Re: Objection to MP08_0244 MOD 1 Modification Request for Mixed Used Development at 23-37 Lindfield Avenue and 11 Havilah Lane, Lindfield

As a resident of Lindfield, I/we wish to lodge an objection against the proposed Modification of the subject development based on the following grounds:

1 HAVILAH LA ELEVATION
2001 SCALE1 : 250

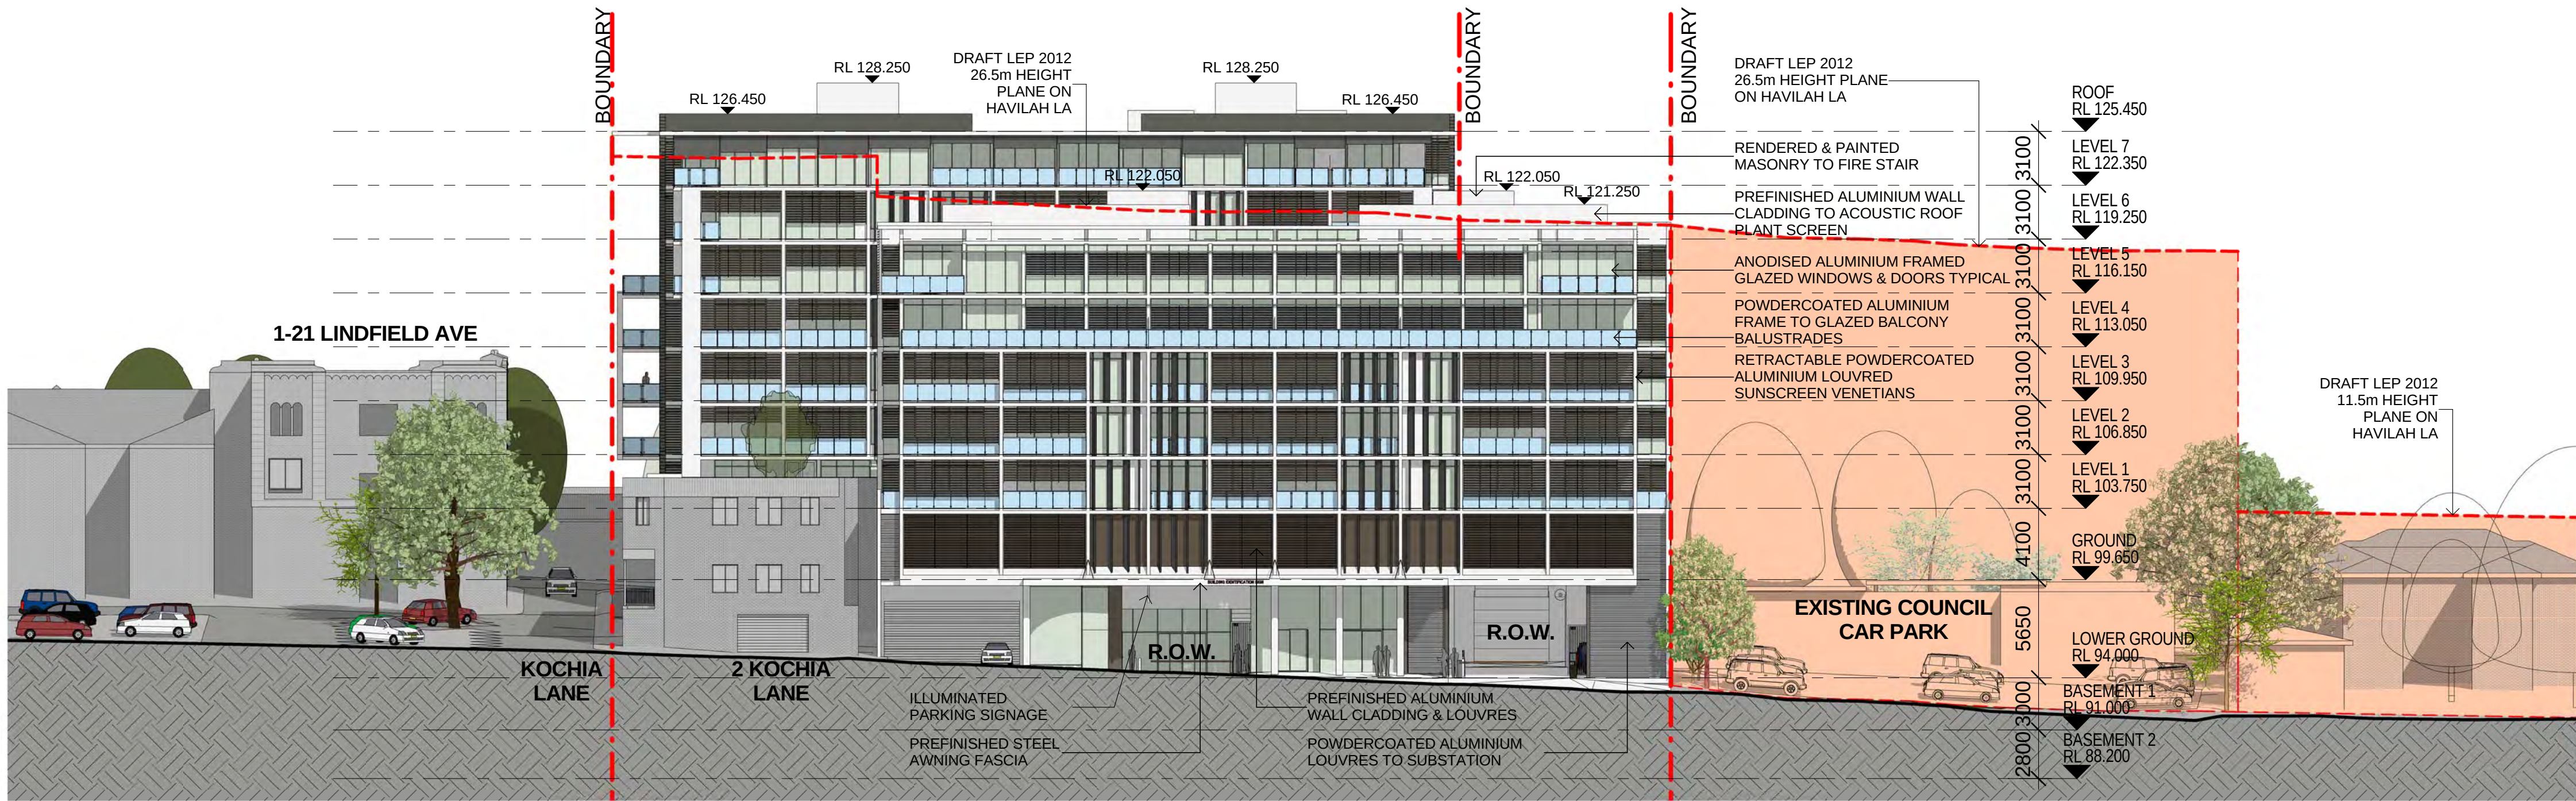
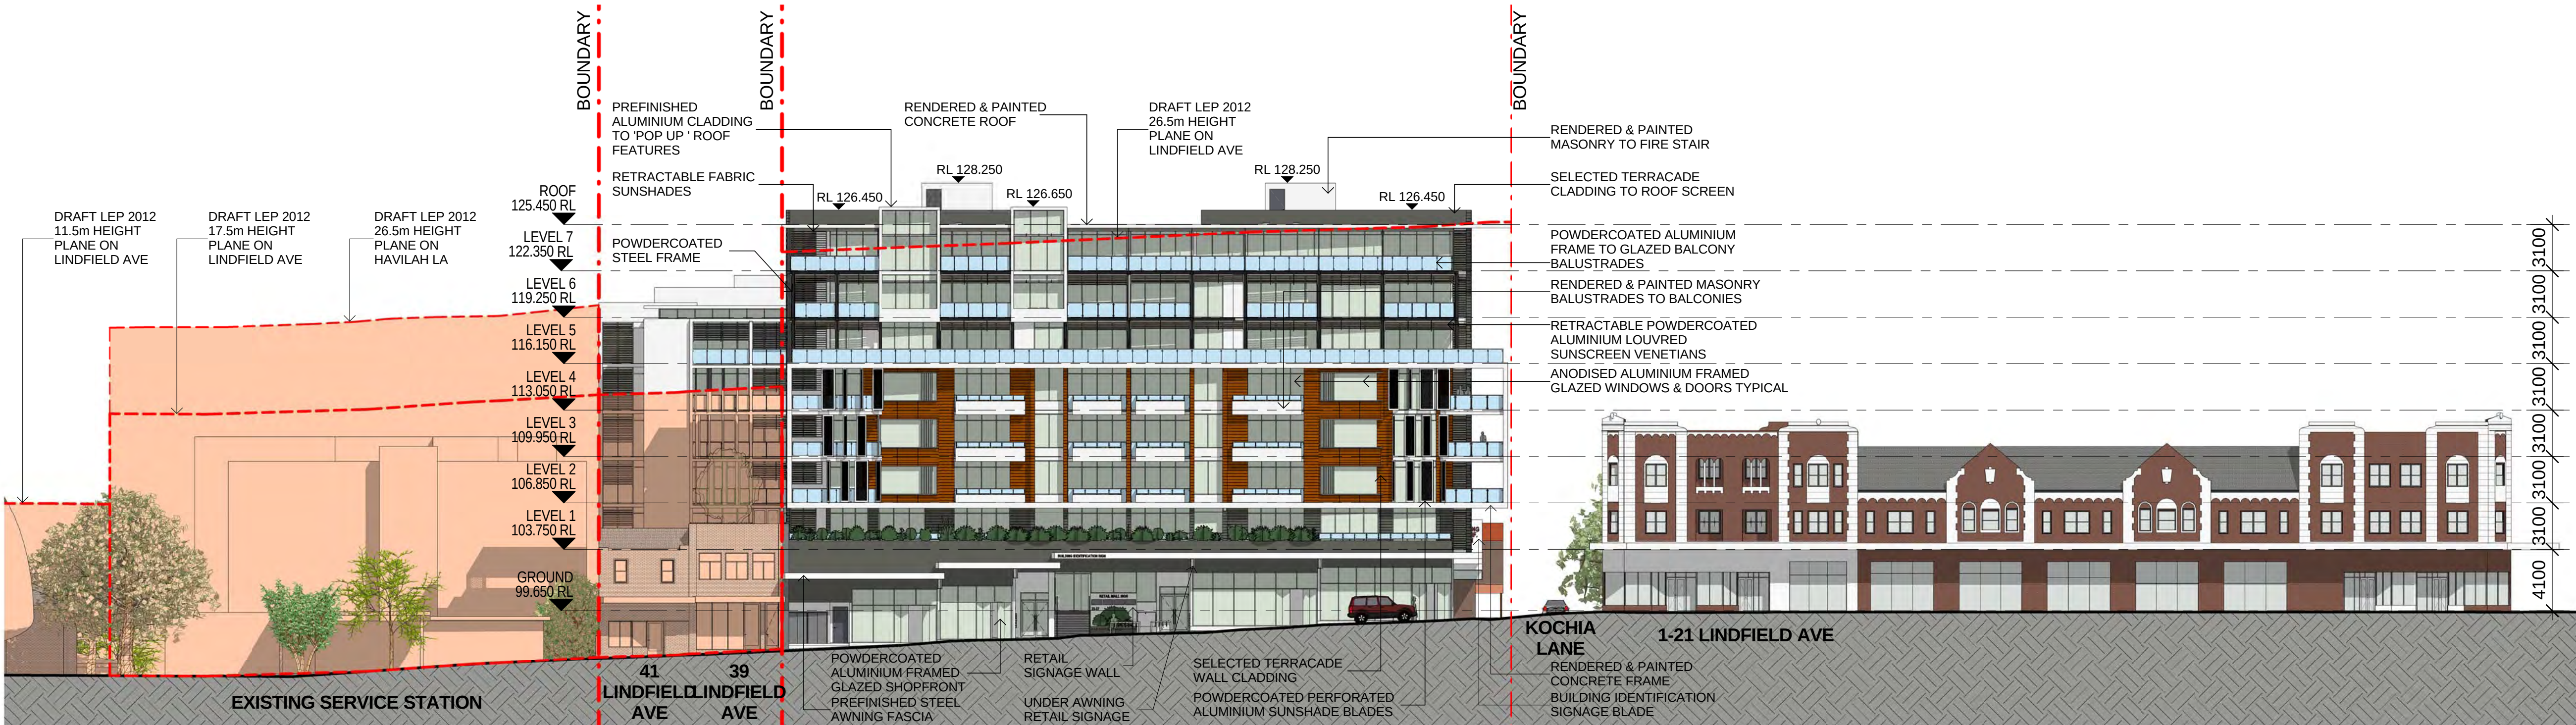
- ✓ The increase of an additional storey to both buildings: 8 storeys on Lindfield Avenue and 7 storeys on Havilah Lane creates excessive height and bulk and is out of character with the surrounding buildings, including the heritage listed adjacent building on Lindfield Avenue

1 SHADOW DIAGRAM - 21stDEC_9AM
5003 SCALE1 : 650

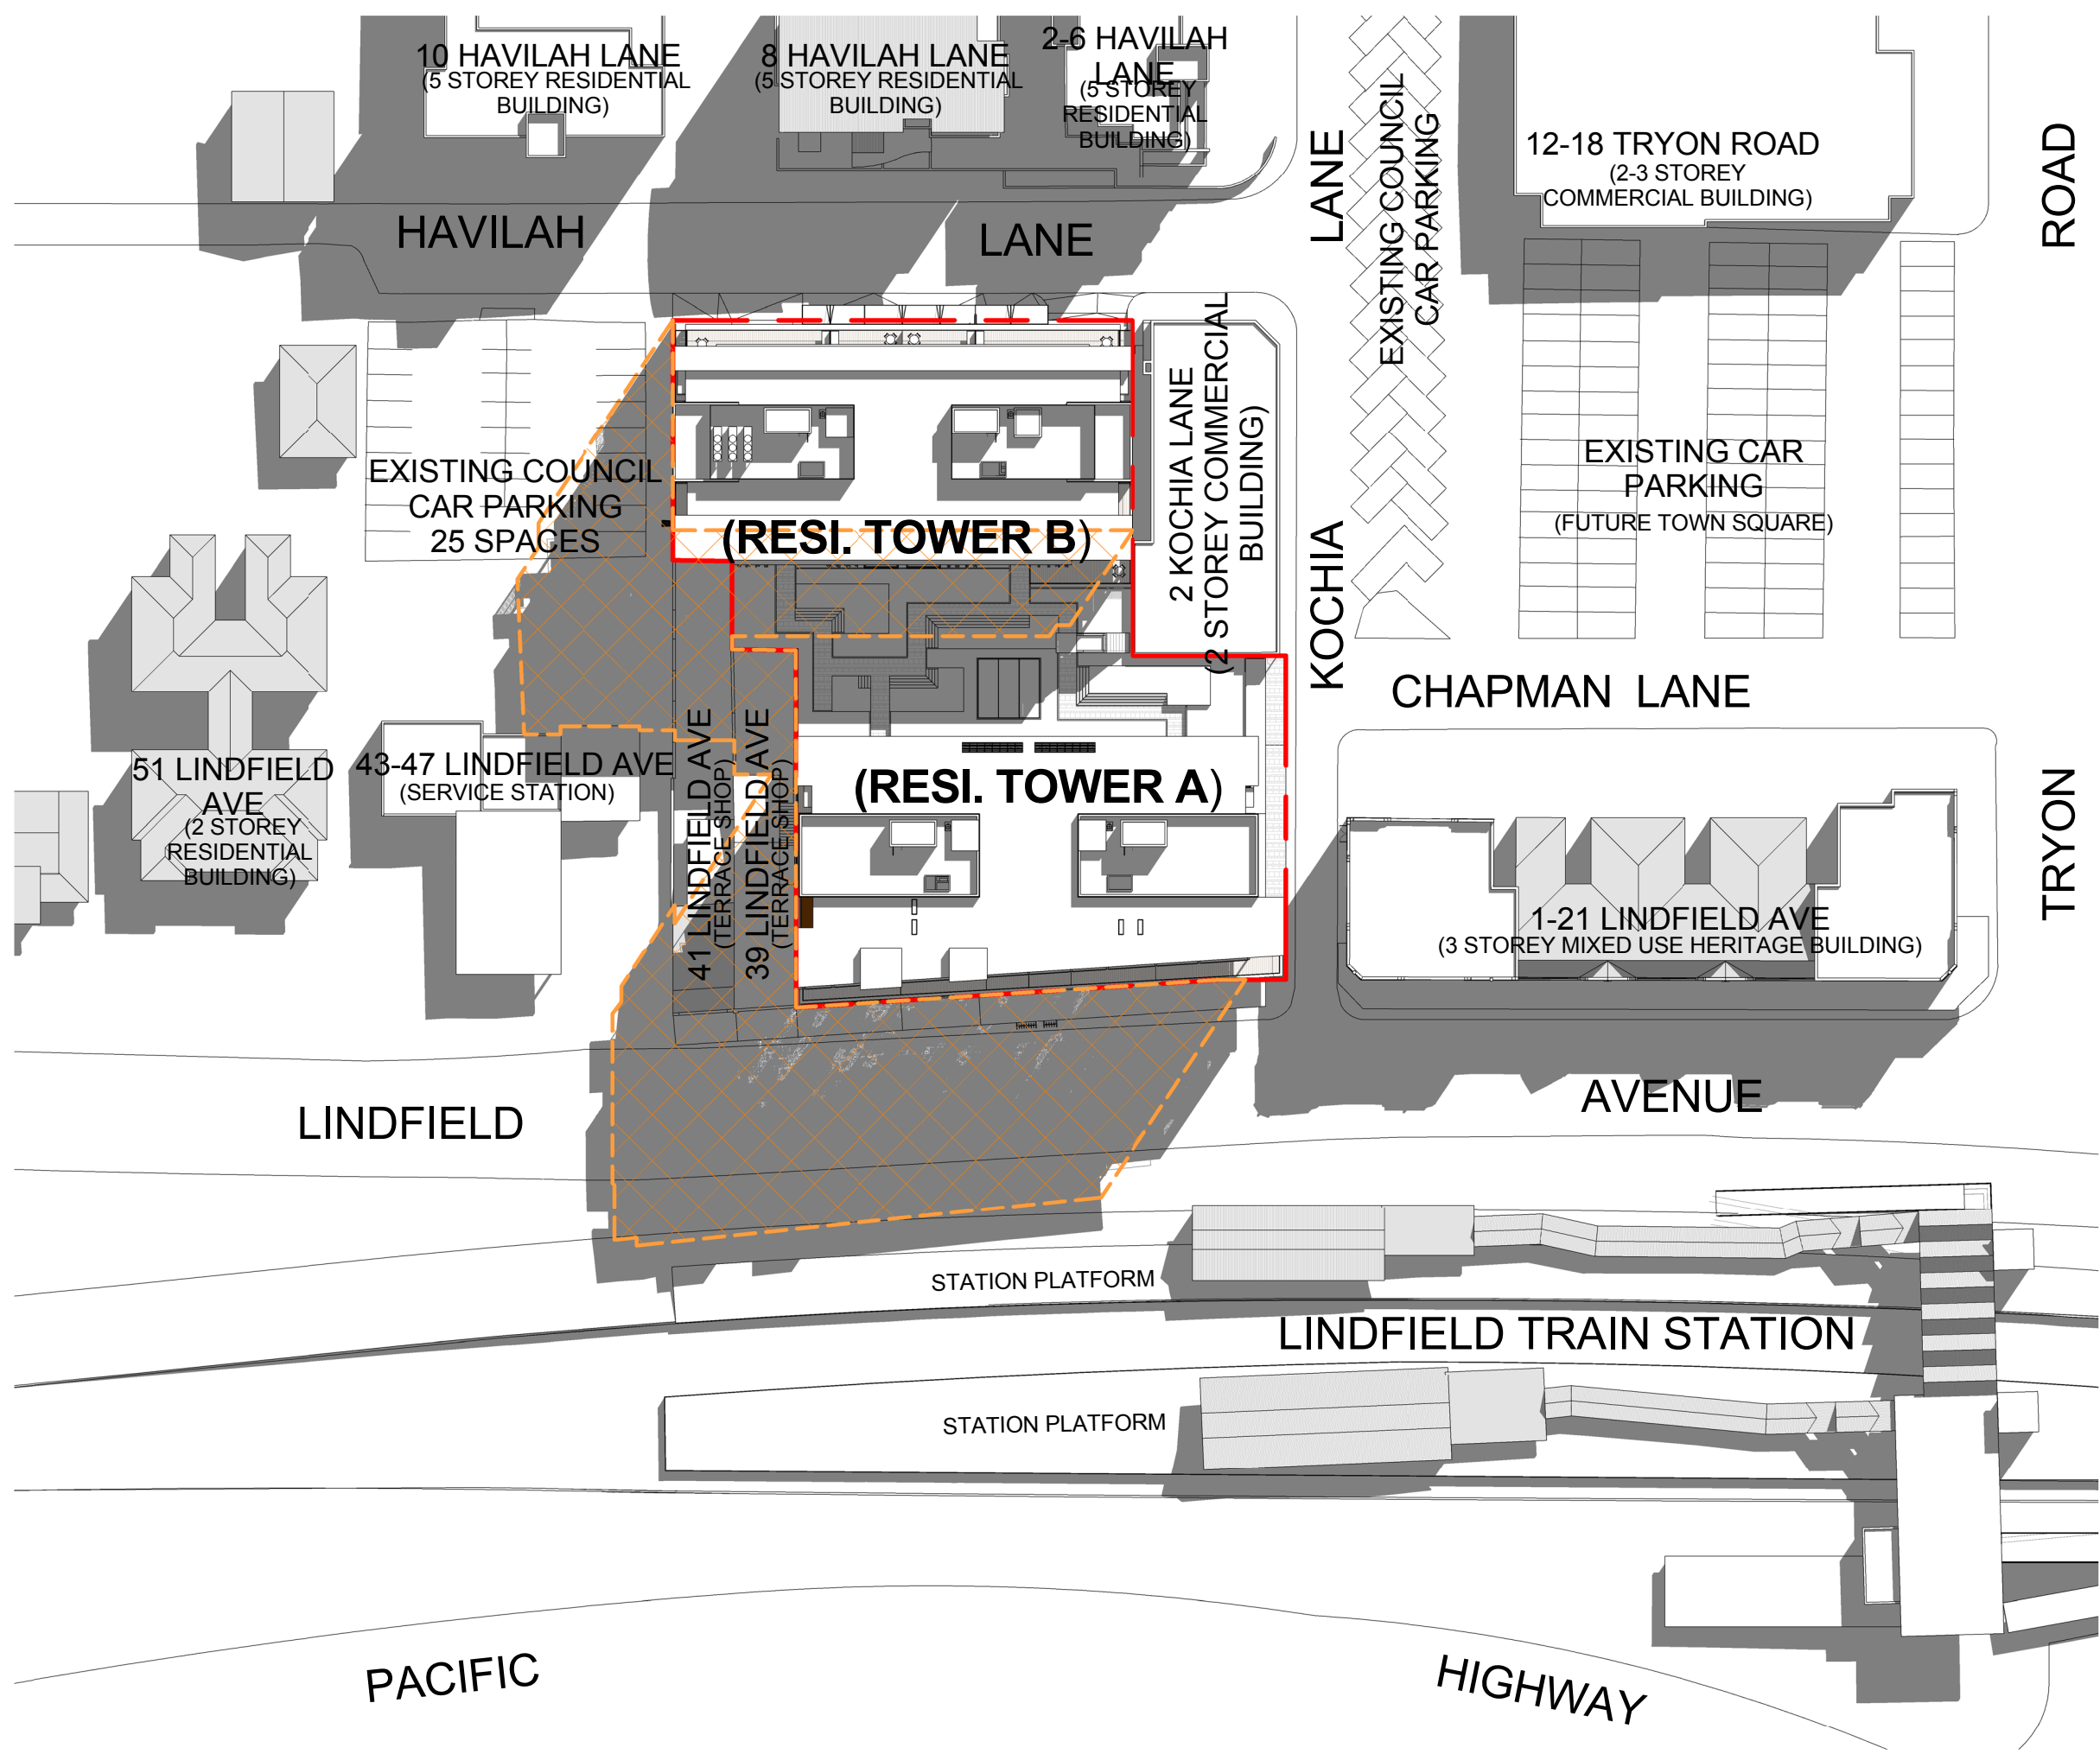
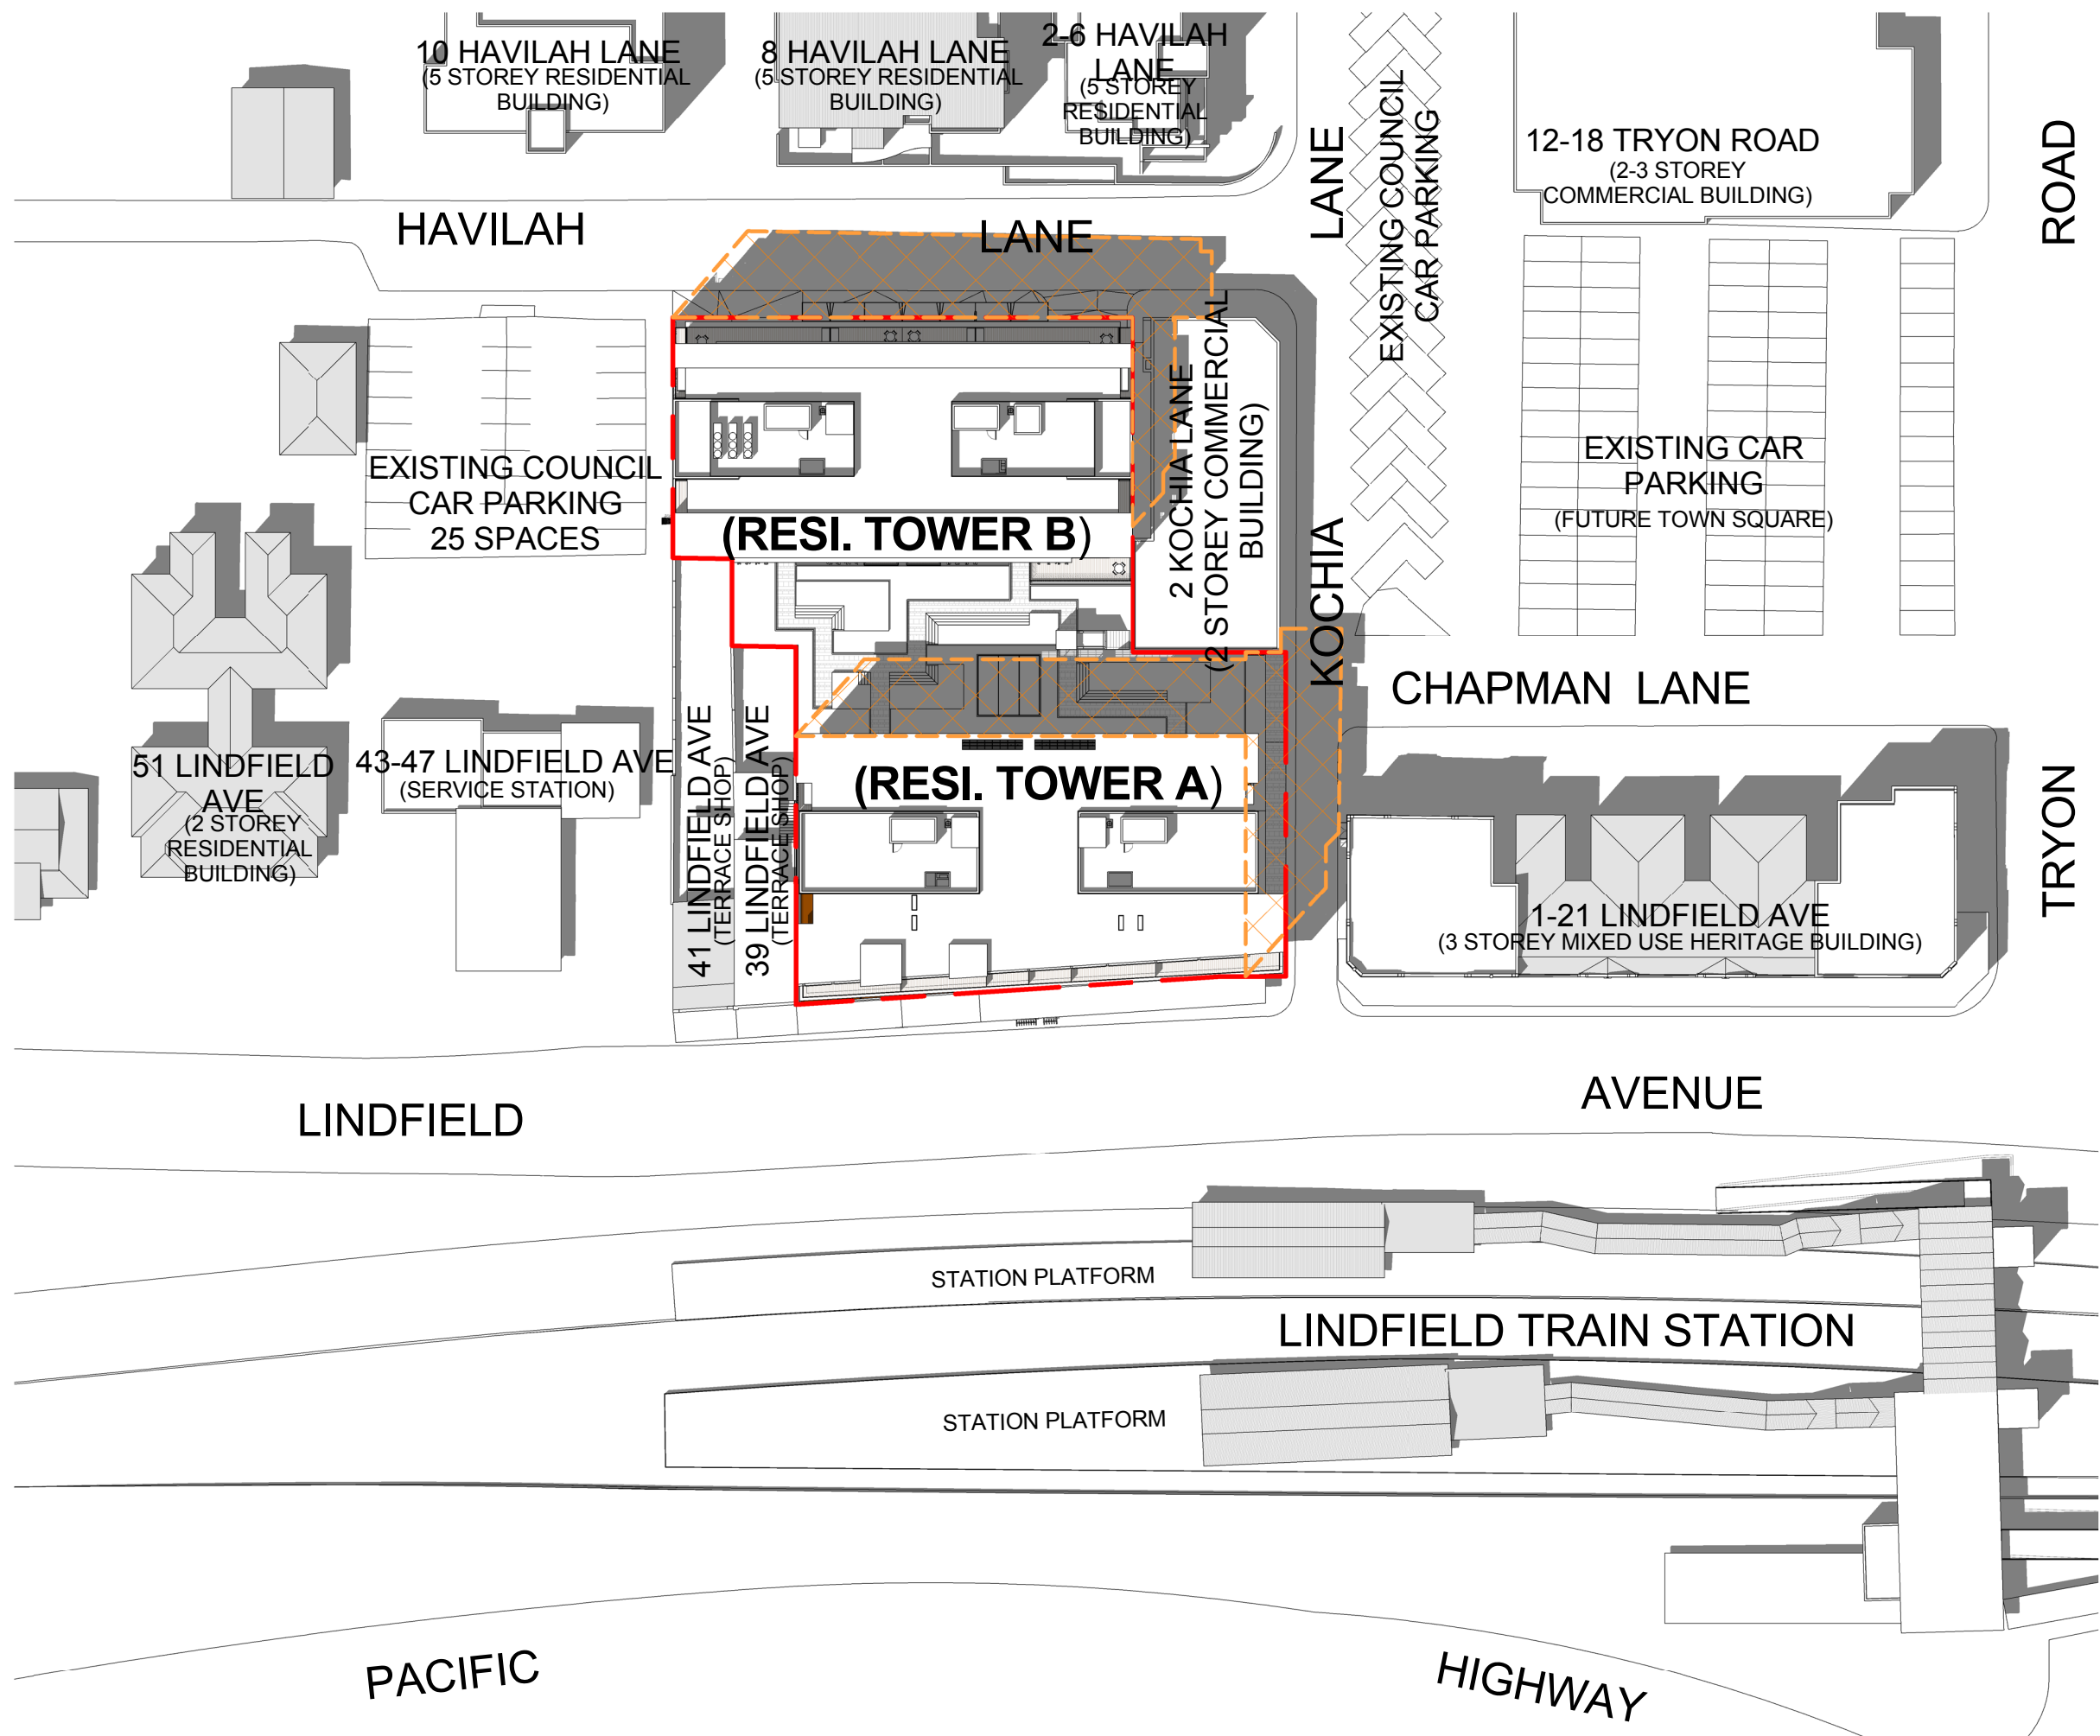
- ✓ The additional storeys create new adverse shadowing: a) for residents in the Havilah Lane apartments, particularly after 3pm b) for the popular outdoor café and central Lindfield hub area at 12 Tryon Road in afternoons, particularly in winter and c) for all commuters on the city bound Lindfield rail platform, instead of 50% of the year as approved, it will now be in shadow in the mornings 75% of the year
